**Dogger Bank South Offshore
Wind Farms**

**The Applicants' Response to East Riding of
Yorkshire Council's Local Impact Report**

Document Date: January 2025

Application Reference: 11.3

**Pre-Examination Procedural Deadline**

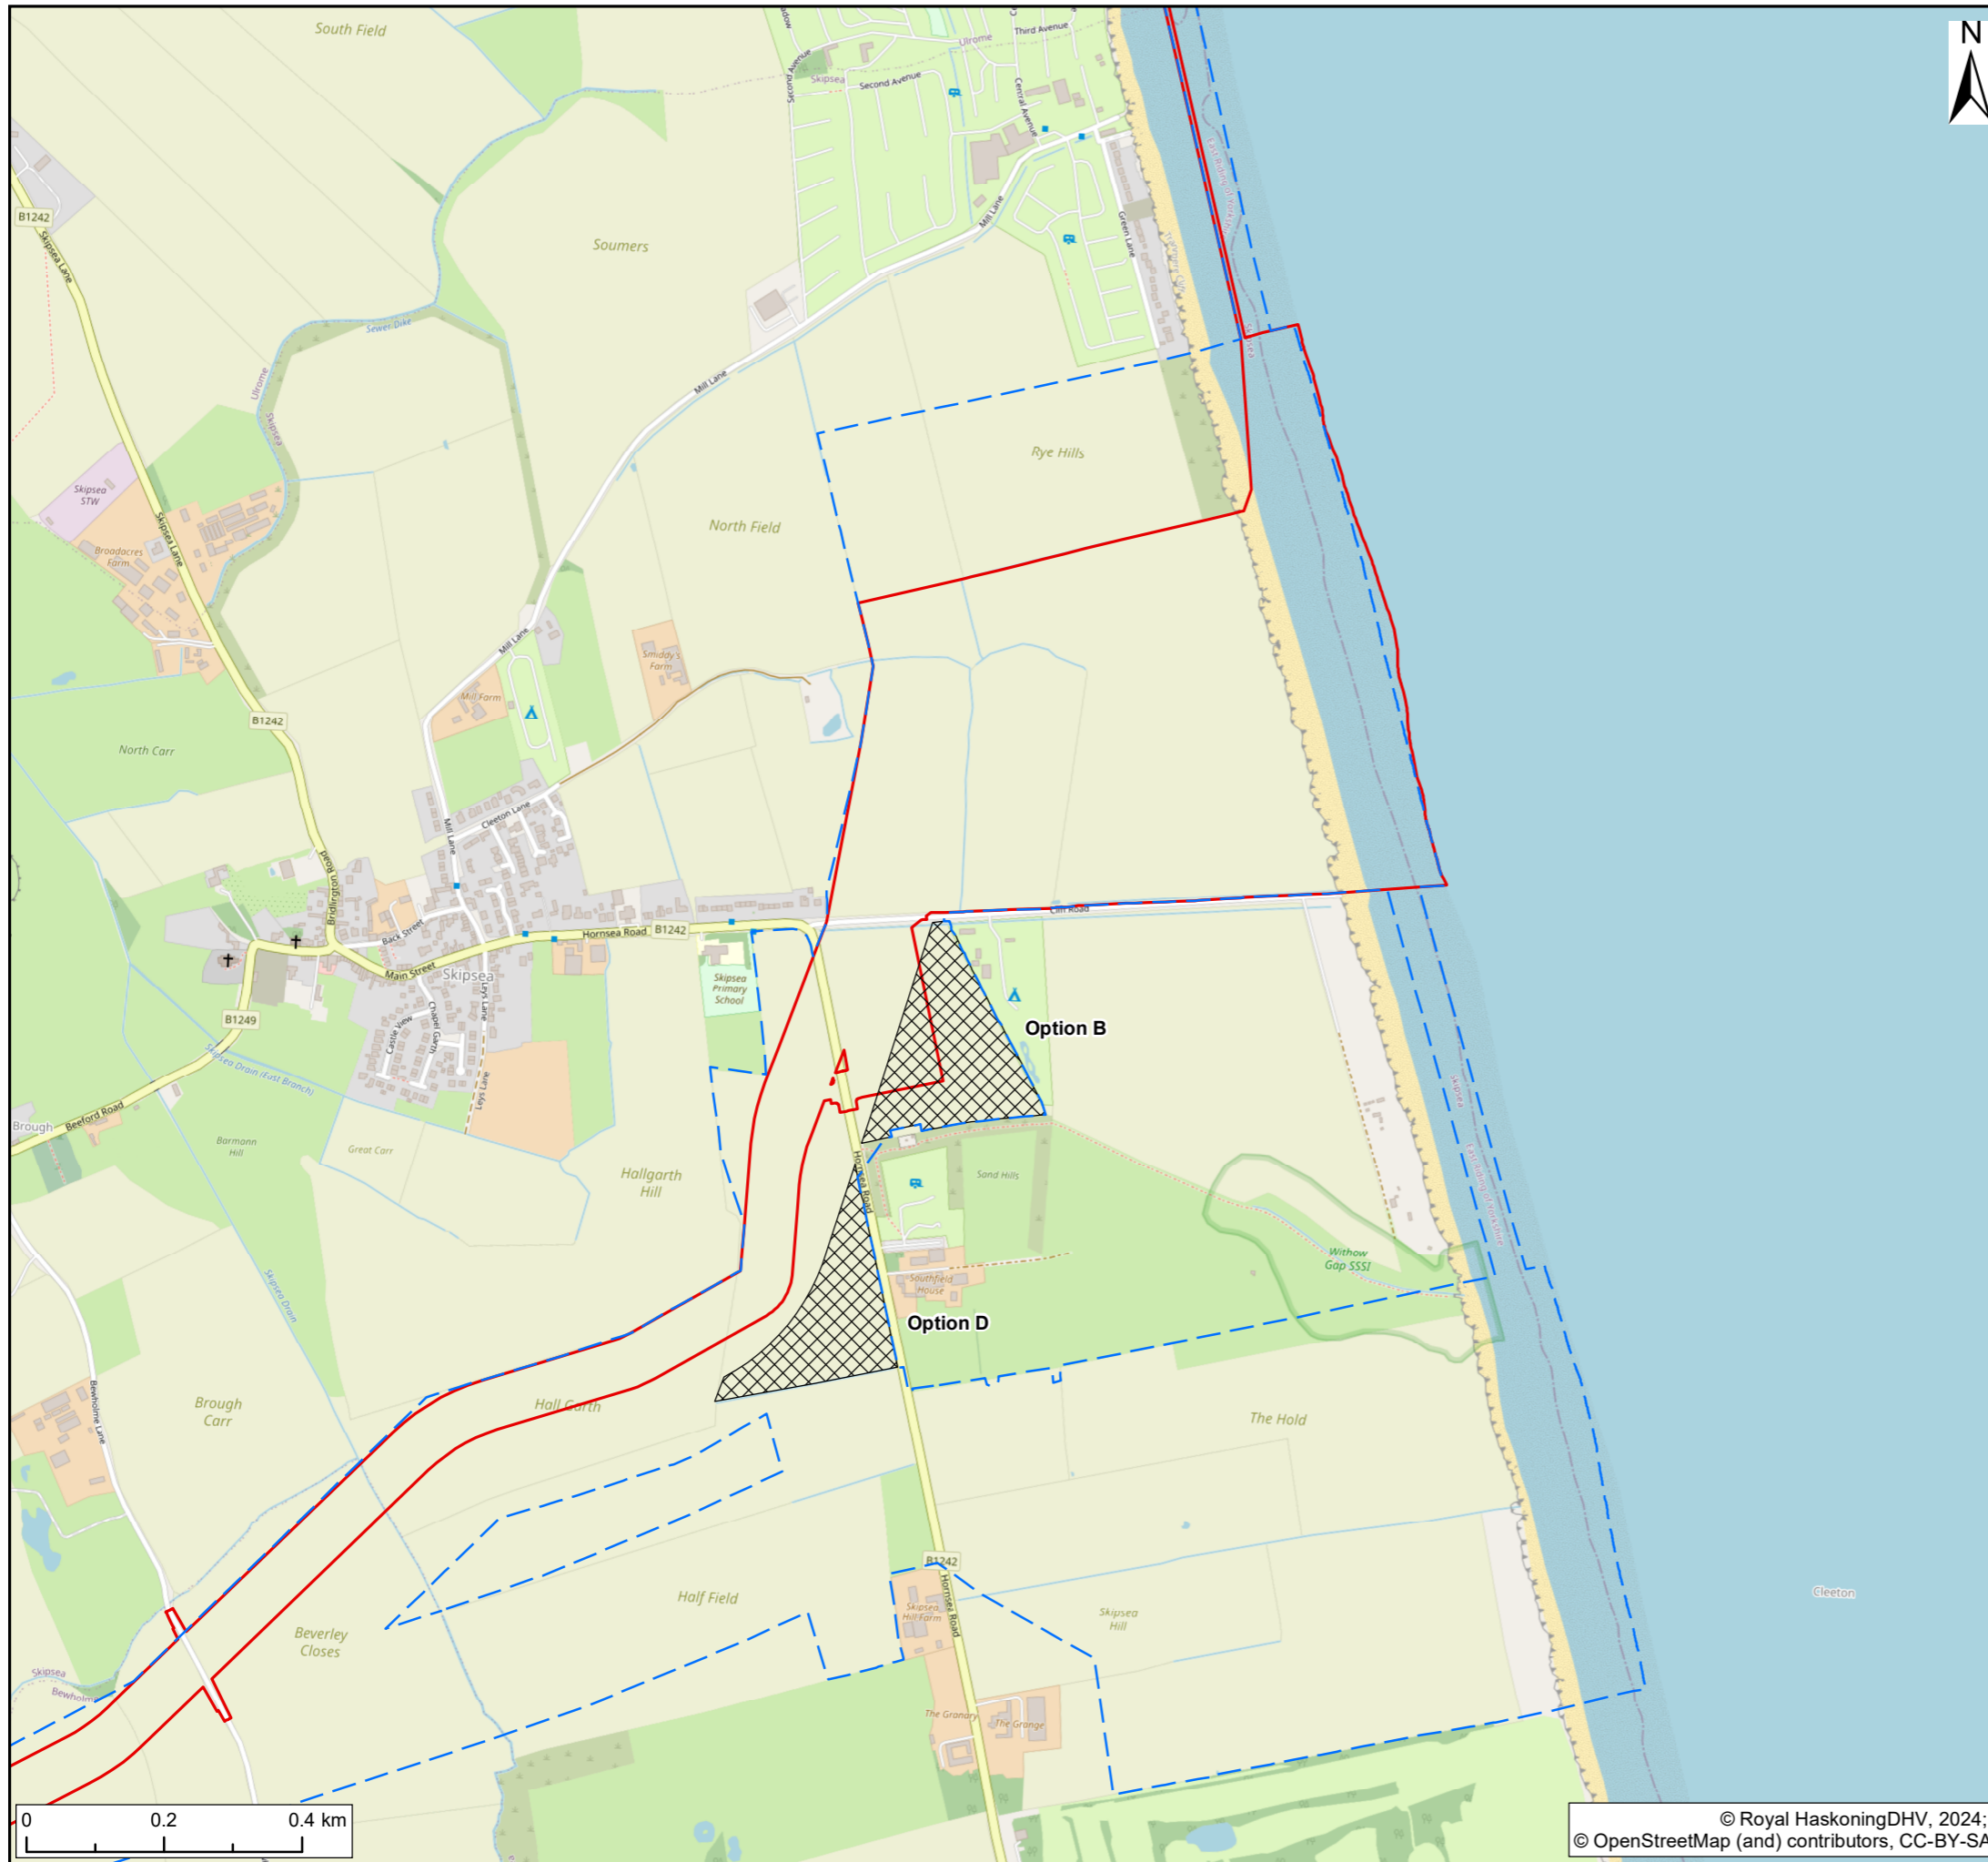
7.11	<p>It was agreed at pre-application stage that the photomontage for Viewpoint 3 would be updated to illustrate earthworks along the access track. This visualisation is presented as Figure 23-9 in Volume 7 (application ref:7.23.1). This has been done, however comparing VP3 to the plan and LVIA text two points arise:</p> <p>a. The ten-year view does not indicate any screen planting to the north of the sub-station, which is shown on the Indicative Landscape Plan</p> <p>b. The LVIA (para 233) notes that: <i>A TCC [Temporary Construction Compound] would be located immediately adjacent to the viewpoint throughout the construction works...</i> The Works Plan (Onshore) Page 18 of 19, also shows a Temporary Construction Compound occupying much of the field to the right-middle-ground of Viewpoint 3. This suggests that the construction effects could usefully be illustrated from this viewpoint.</p>	<p>The Year 10 visualisation for Viewpoint 3 does include mitigation planting to the north of the Onshore Converter Station. This is difficult to see in the image for two reasons:</p> <ol style="list-style-type: none"> 1. The topography rises from the viewpoint, then falls towards the onshore converter station. The screen planting would be located at a point lower than the foreground topography, and along with the lower parts of the onshore converter station would be partly out of sight. 2. The photograph shows a winter view. During winter, deciduous planting would lose its leaves, reducing its screening function. The upper branches of mitigation planting are shown in the visualisation but are not clearly visible due to distance and the scale of the image on paper. <p>The screen planting would be more visible during summer, and would continue to mature beyond Year 10, increasing its screening effect in the long term.</p> <p>As part of the Project Change Request 2 [AS-152], the Onshore Converter Stations will be reduced in extent, and the massing will be less visible in this viewpoint. Updated visualisations showing the revised Onshore Converter Station will be presented at Deadline 2.</p> <p>An additional visualisation for Viewpoint 3 showing the extent of the Temporary Construction Compound, and a 2.5m fence, forms Appendix A of this document.</p>
